**From:**  
**Sent:** 04 June 2026 23:53  
**To:** Louise Bearcroft; DC Admin  
**Subject:** Objection to Planning Applications 2025/61/92713

Objection to Planning Applications 2025/61/92713

I wish to comment on the [Delegated Report / Committee Report \[id 1142153\]](#) Committee Report for Strategic Planning Committee 11 June 2026 and raise an objection against the two planning application in relation to the number of times Kirklees planners have not followed their own SPD's and LP in order to try and push this application through on behalf of this builder.

Appendix 4: Proposed Development Plan

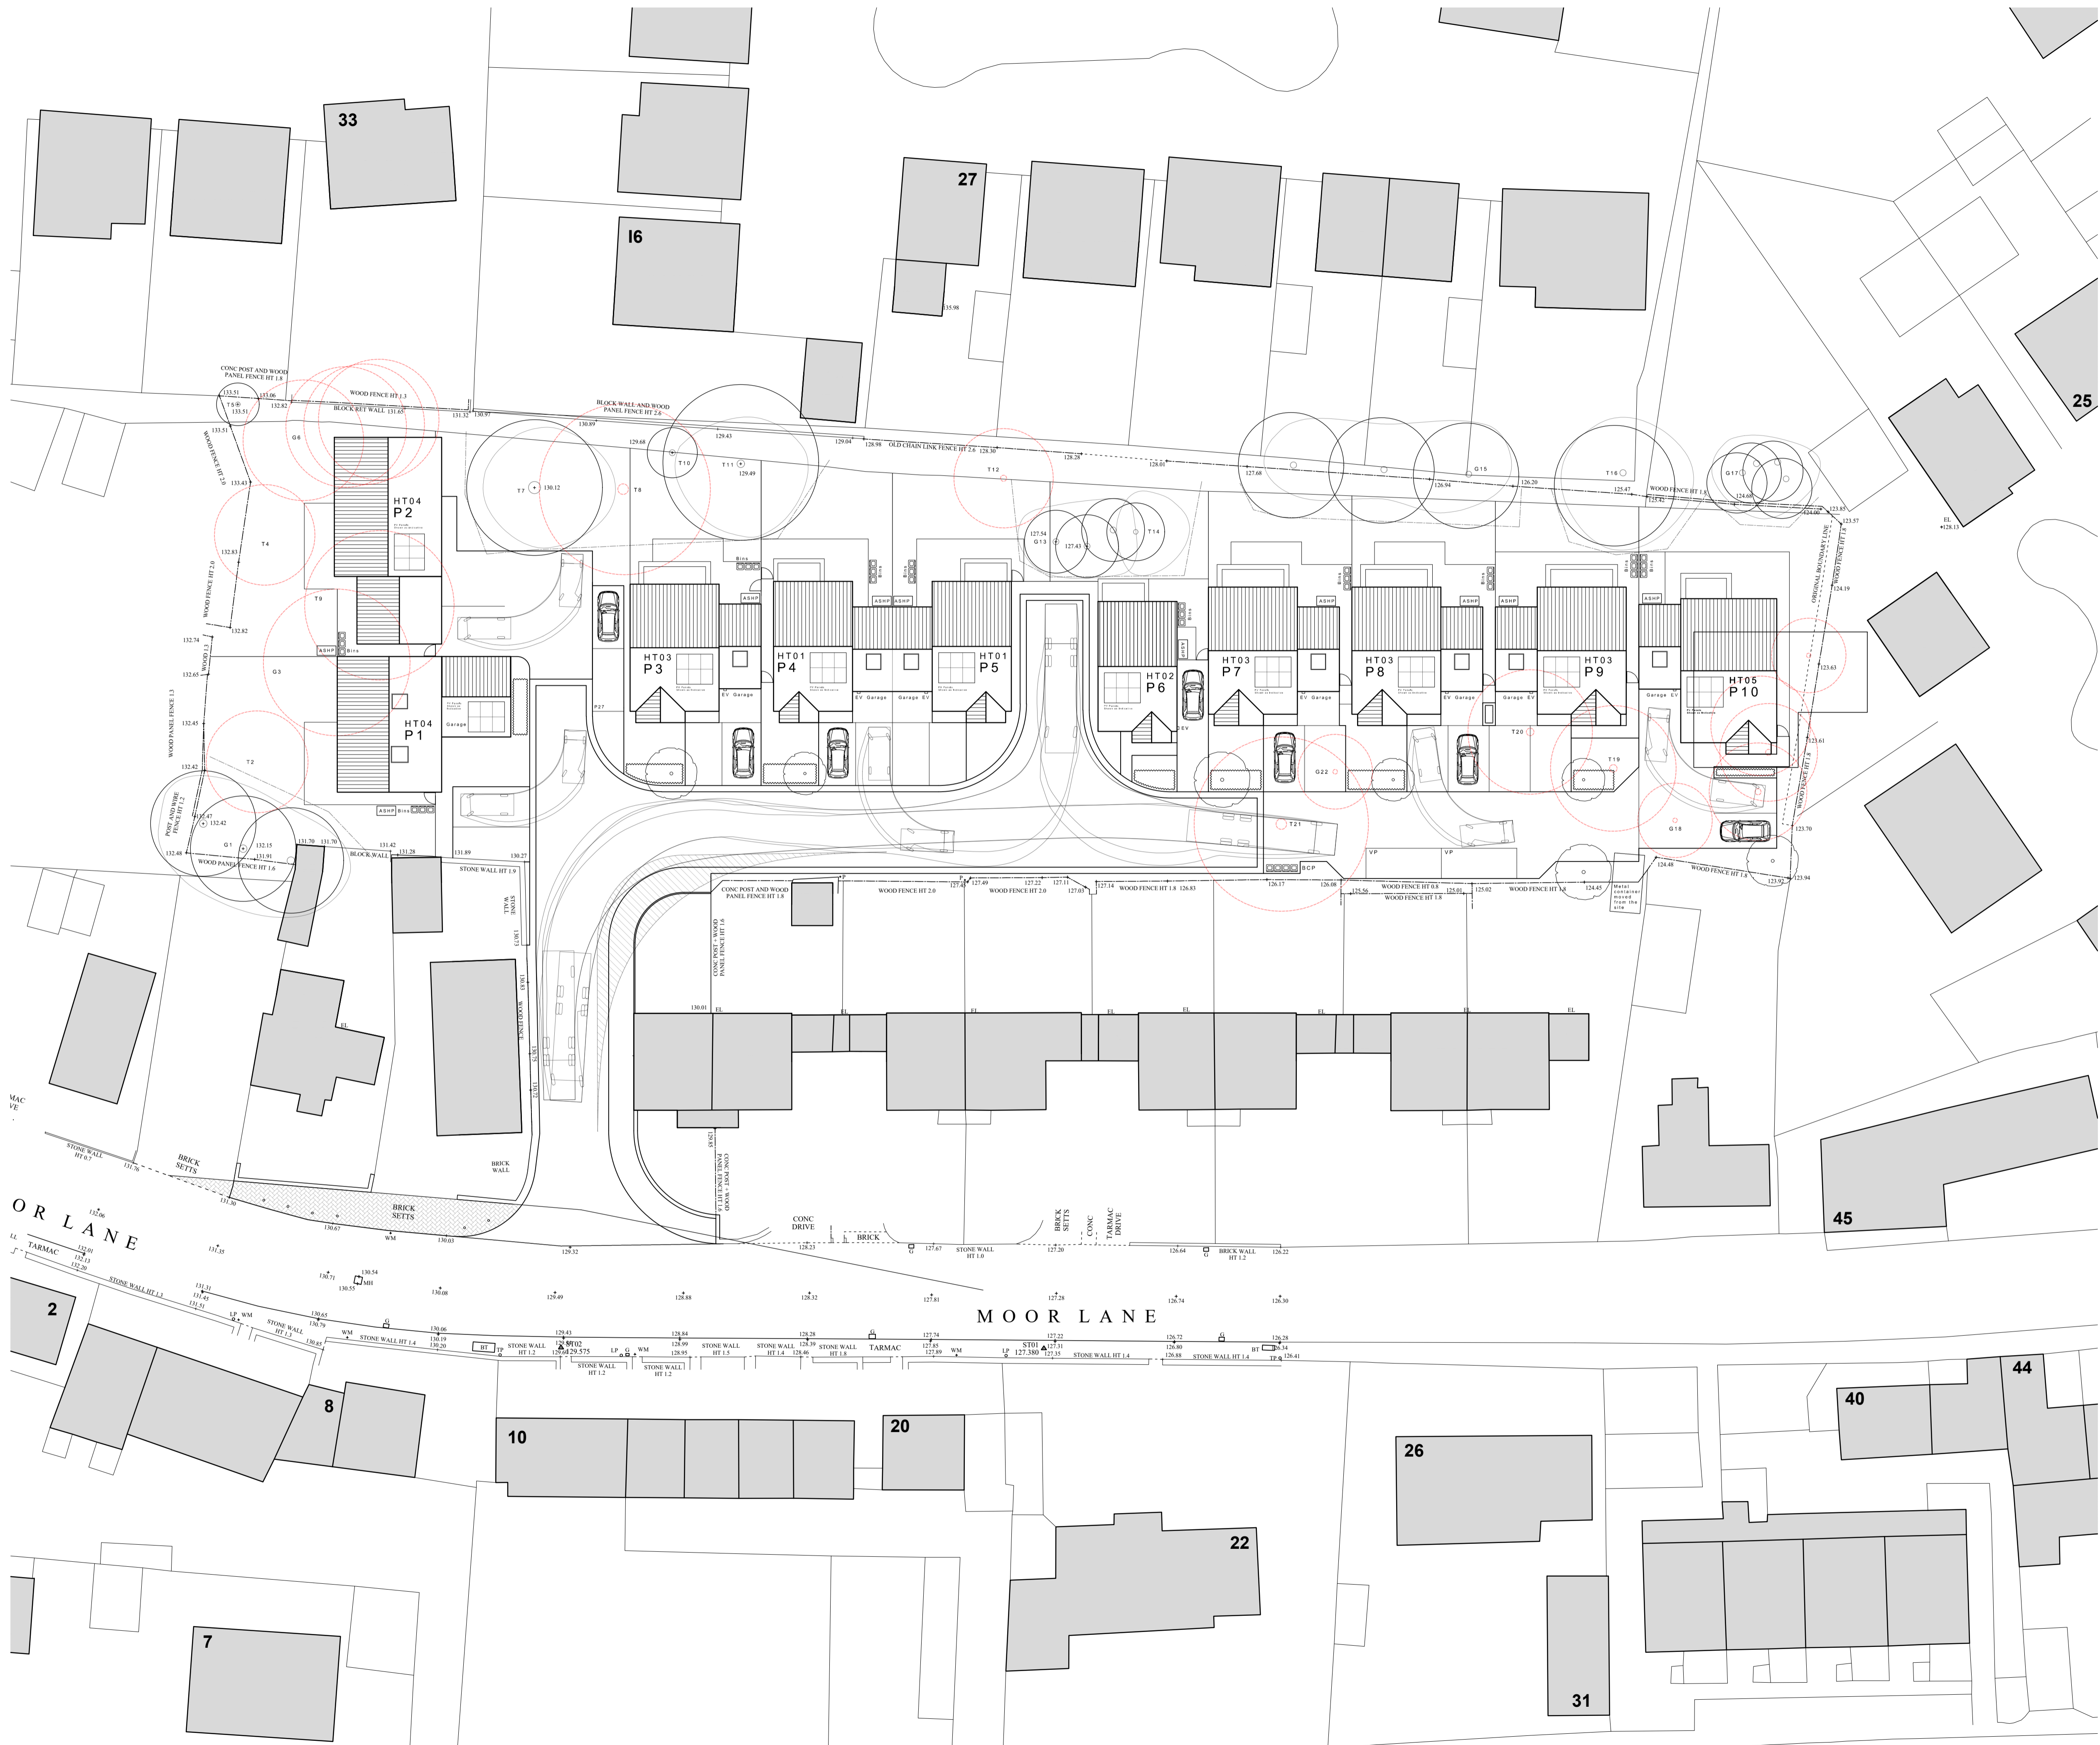
**10.14 Minimum separation distances between 21 Summerdale and Plot 10.** Principle 6 of the adopted Housebuilders Design Guide SPD specifies 12 metres between windows of habitable rooms that face onto windows of a non-habitable room. It does not differentiate between ground floor windows and 1<sup>st</sup> floor windows. If a window exists in a wall it should be taken into account as specified in Principle 6 of the adopted Housebuilders Design Guide SPD.  
**Planners find it acceptable**

**10.15 SPD requires that longer distances between buildings may be necessary where there is steep topography on the site.** The planners have only taken into account the difference between ground and floor levels of these two houses. Added to this the difference in the height of the ridge tiles Plot 10 will overshadow 21 Summerdale. This has been acknowledged in point 10.28.

**10.29** “The side facing upper floor windows of Plot 10 would serve bathroom/en-suite areas and therefore be obscurely glazed (to be secured by condition) to avoid potential overlooking” Just because these window have obscure glazing in them does not mean the window do not open. This means residents can look out of an open window into 21 Summerdale’s window. This is why the SPD specify non habitable windows (i.e. bathroom windows) have minimum separation distances applied to them. Again **Kirklees planners not following their own recommendations and procedures. Planners find it acceptable.**

**10.32** Plot 1 (HT04) is referred to as a 5 bed, 7 person at **3 storeys** 125m<sup>2</sup> Proposal 225.21m<sup>2</sup>.

In point 10.44 Plot 1 is referred to a 2 storey building. Planner’s advise that this plots’ eaves will be higher, consequently the ridge tiles will be higher. This makes Plot 1 taller than a 2 storey building. Another example how planning are bending the rules and not adhering to the principle (2 storey buildings only) on which the previous committee meeting passed the original outline planning permission for this site. This plan is placing a 3 storey building in the vicinity of a grade 2\* listed building which contravenes previous planning concerns that were raised at outline planning committee meeting. **Again Kirklees planners not following their own recommendations and procedures. And find it acceptable**

- **10.38 Bin drag distances for plot 5-10 exceed the recommended maximum.** Plots 5-10 would have greater drag distances than the recommended guidance. The maximum drag distance for a resident is 25 metres. Plot 10 and 9 will have a drag distance of approximately 40 metres. How can planners describe this excessive distance as “This is not an ideal situation, however the drag distance is not so significant to amount to significant material harm”. **In excess of 15 metres more than the maximum is significant especially when dragging a bin up an incline.** Putting the onus on the developer to ensure future residents are aware, does not make this issue comply with Kirklees Housebuilders Design Guide SPD. **What a blatant disregard of planning rules, for everyone to see. Again Kirklees planners not following their own recommendations and procedures. And find it acceptable**

- **10.39 Visitors parking spaces.** “Officers acknowledge the concerns from K.C. Highways, however other layout and location options for the visitor parking spaces have been explored and it is considered to be the best option” In this point we have general planning officers acknowledging K.C. Highways have shown concerns but planners feel they know better than the expert department and just accept the best option for the builder rather than recognise that the plans do not comply with planning regulations. In 10.4, here we have the term again “considered acceptable”, even though K.C. Highways do not consider it acceptable. **Again Kirklees planners not following their own recommendations and procedures. And find it acceptable**
